Elevation Plans_V1.pdf Markup Summary

FRONT ELEVATION - BUILDING TYPE C
Scale: 3/32" = 1'-0"

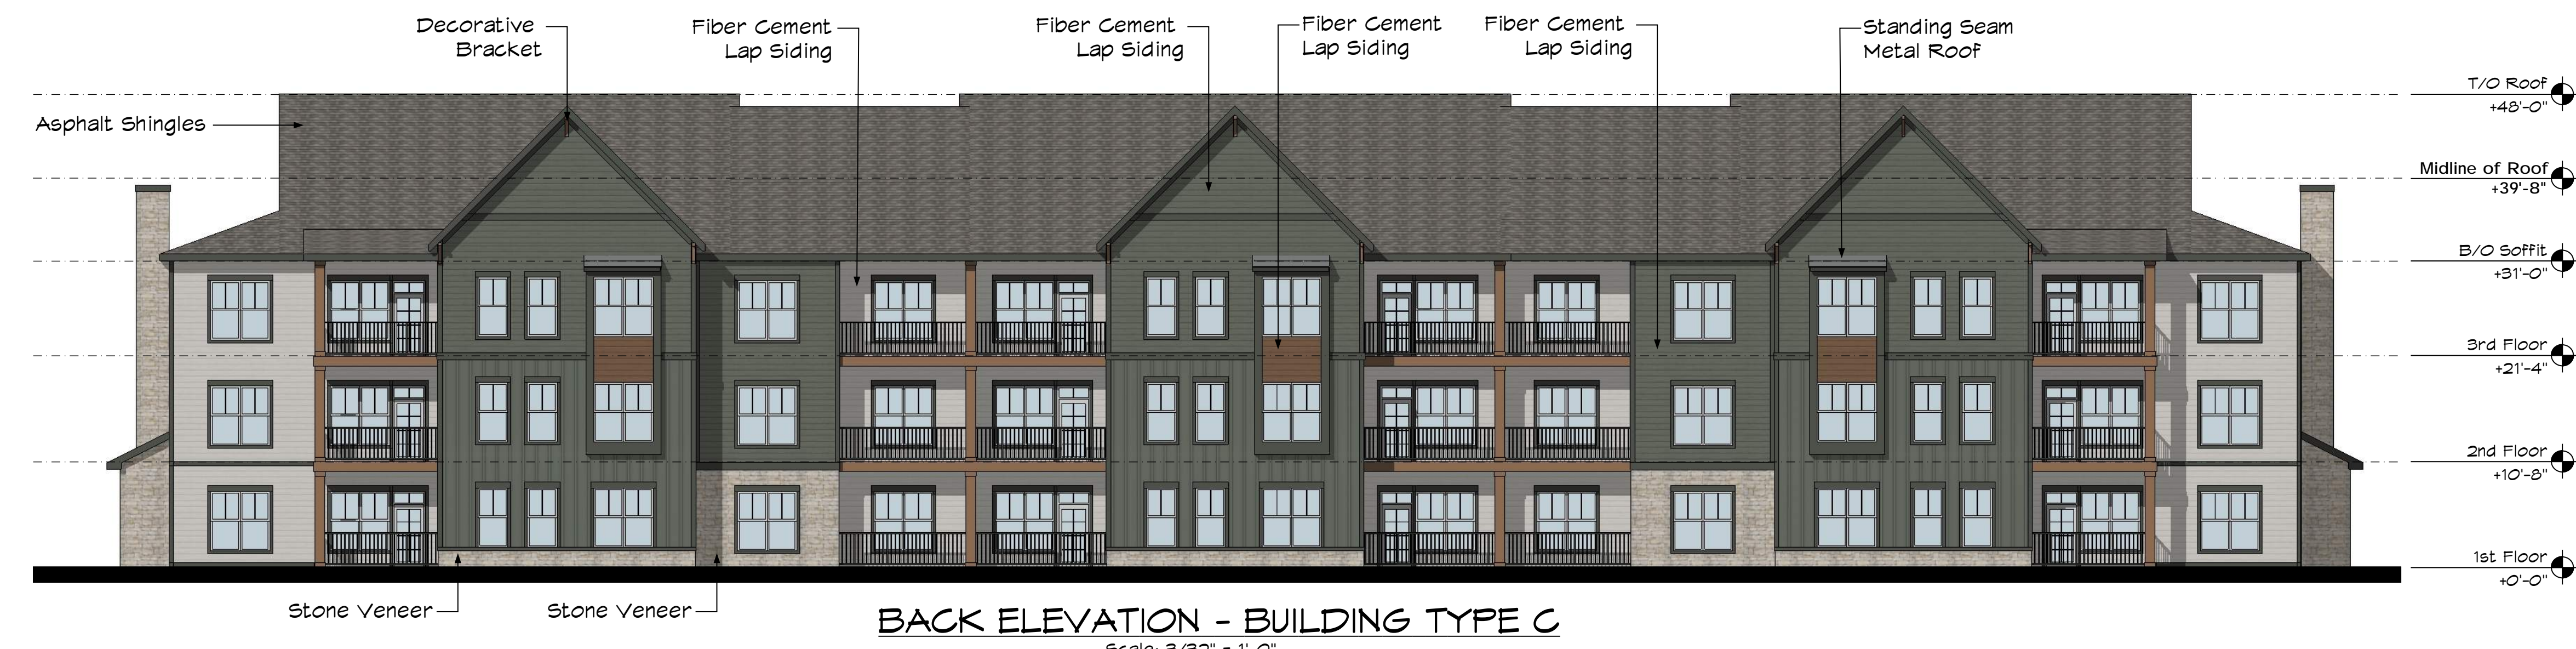
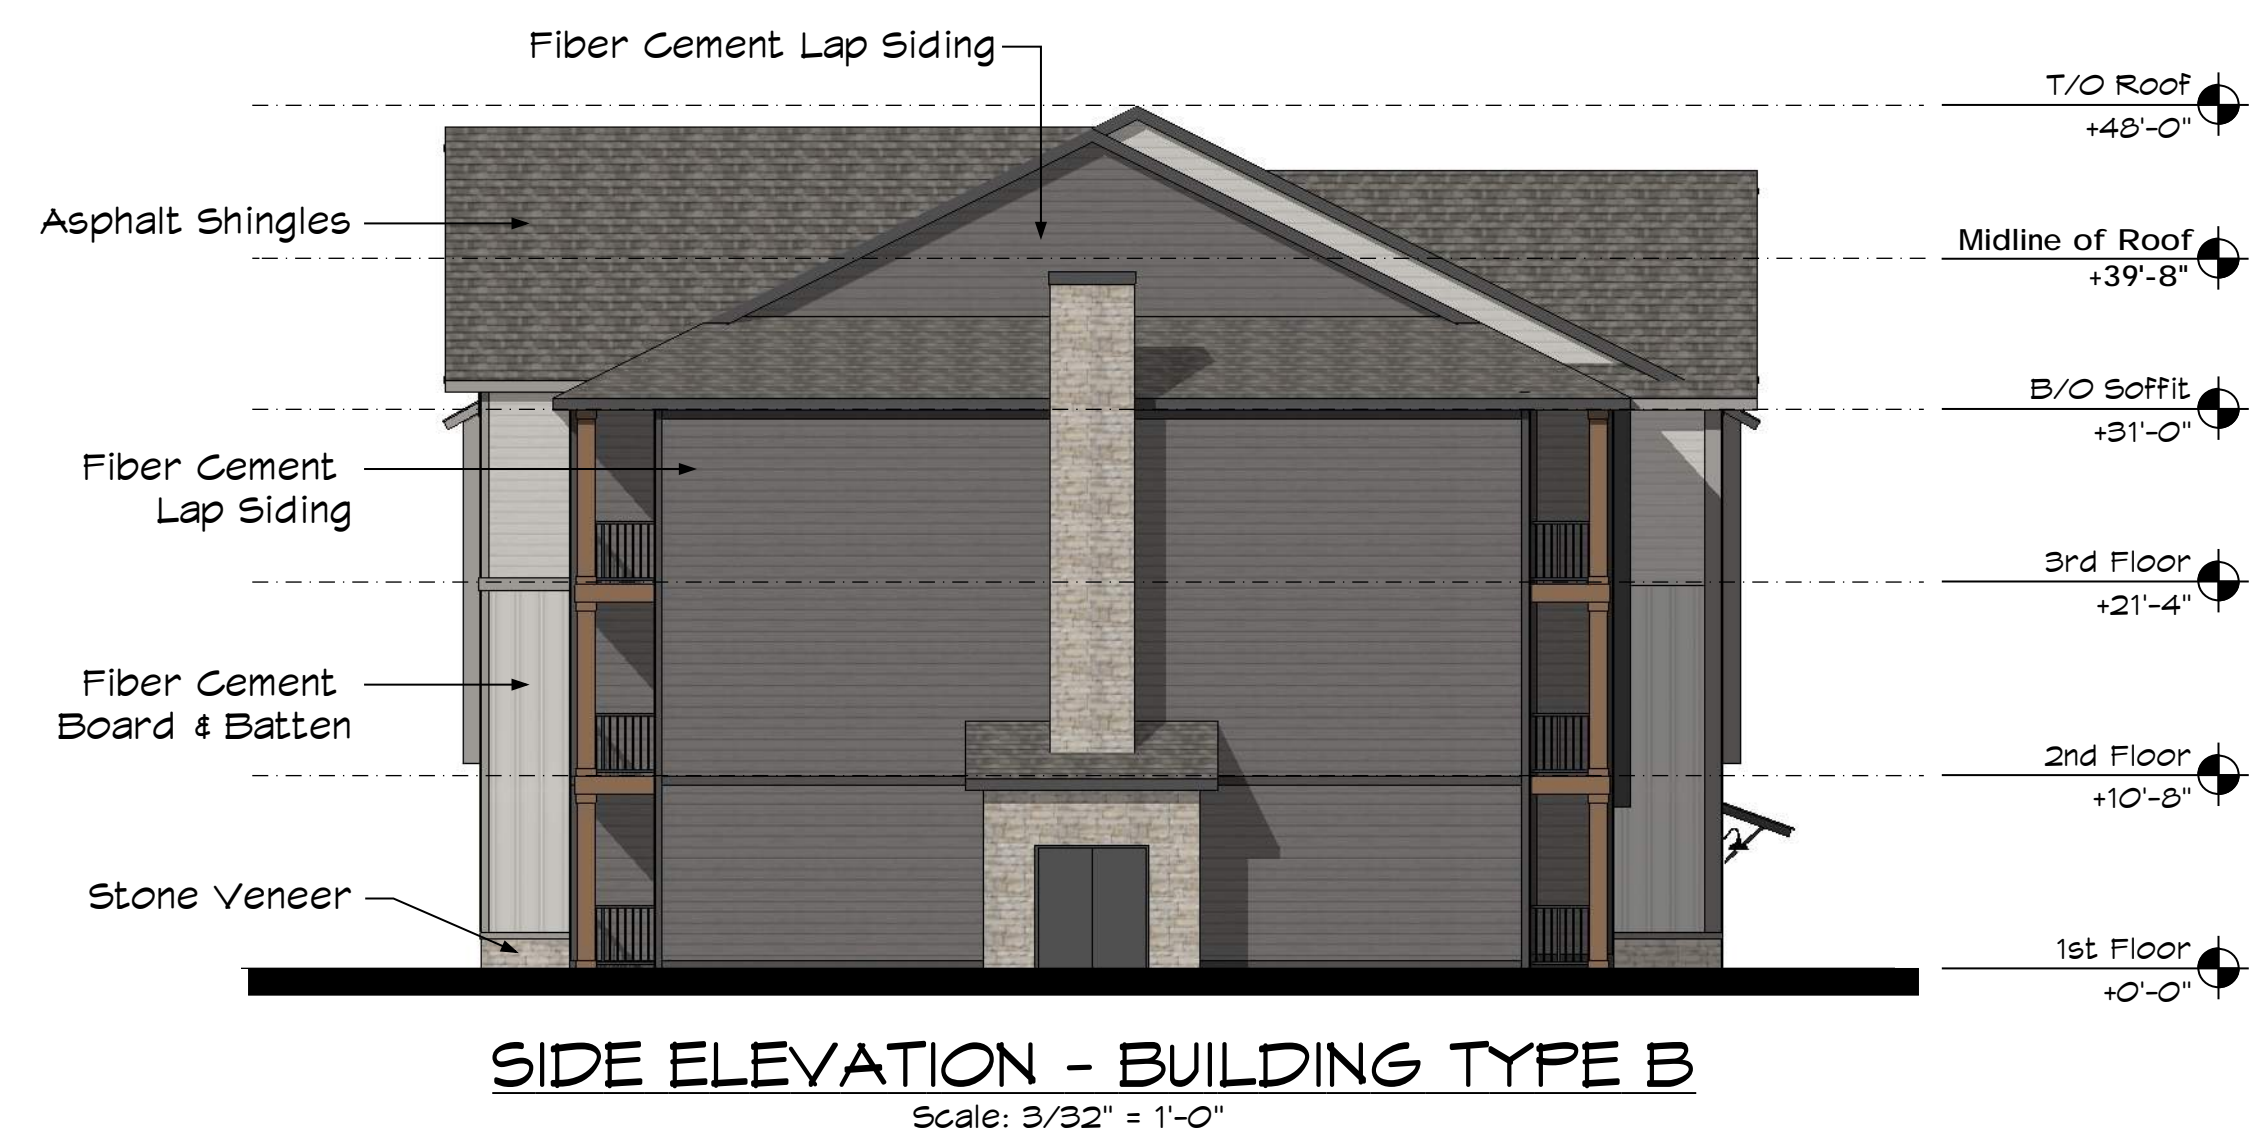
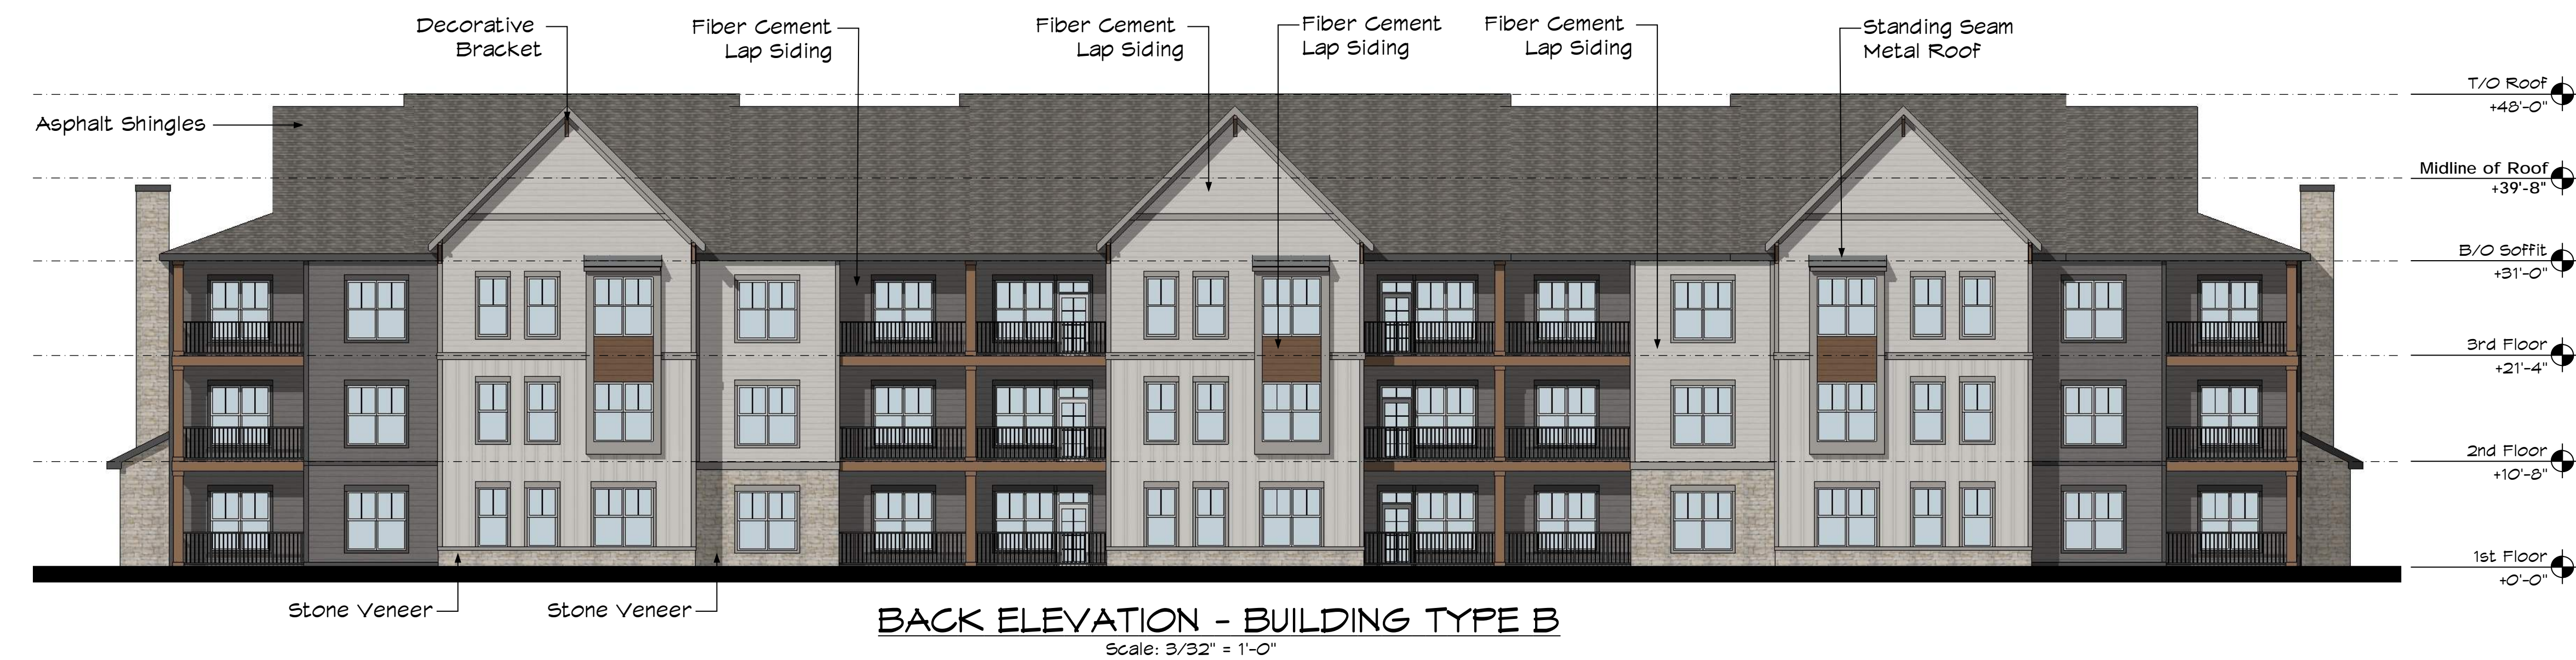
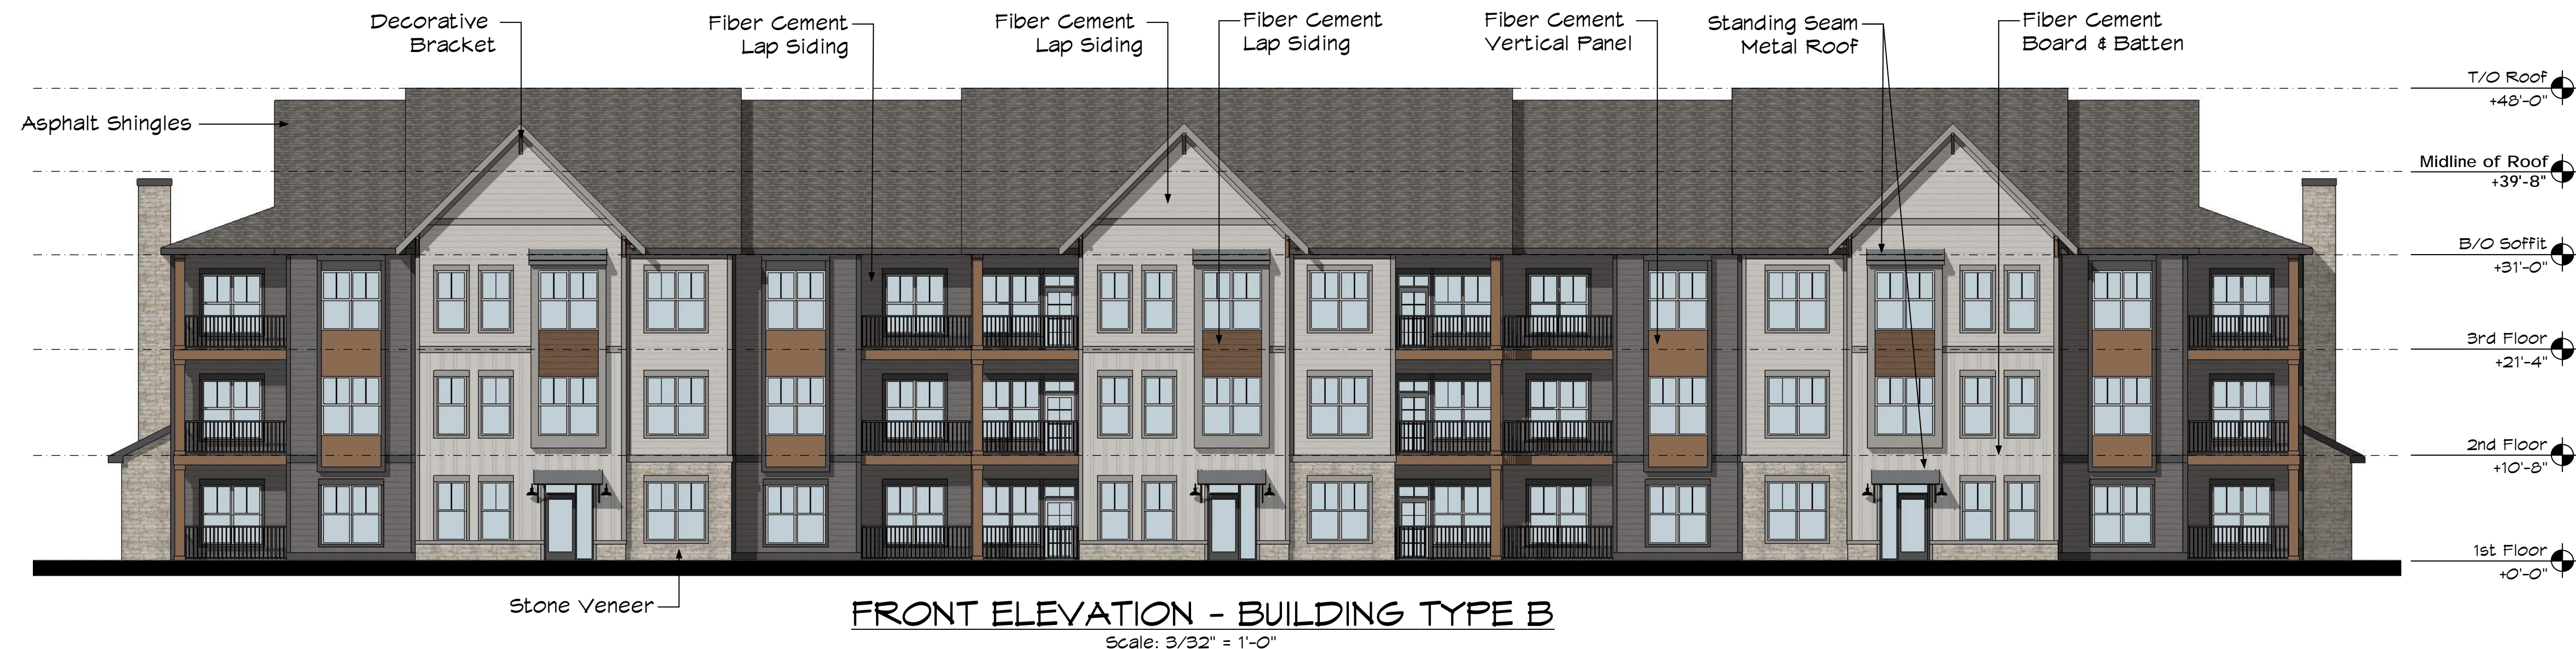
Because allowed building height is max. 40 height, please show the average roof height to demonstrate that the 40' to top of roof-line still meets the height limitations.

Because allowed building height is max. 40 height, please show the average roof height to demonstrate that the 48' to top of roof-line still meets the height limitations.
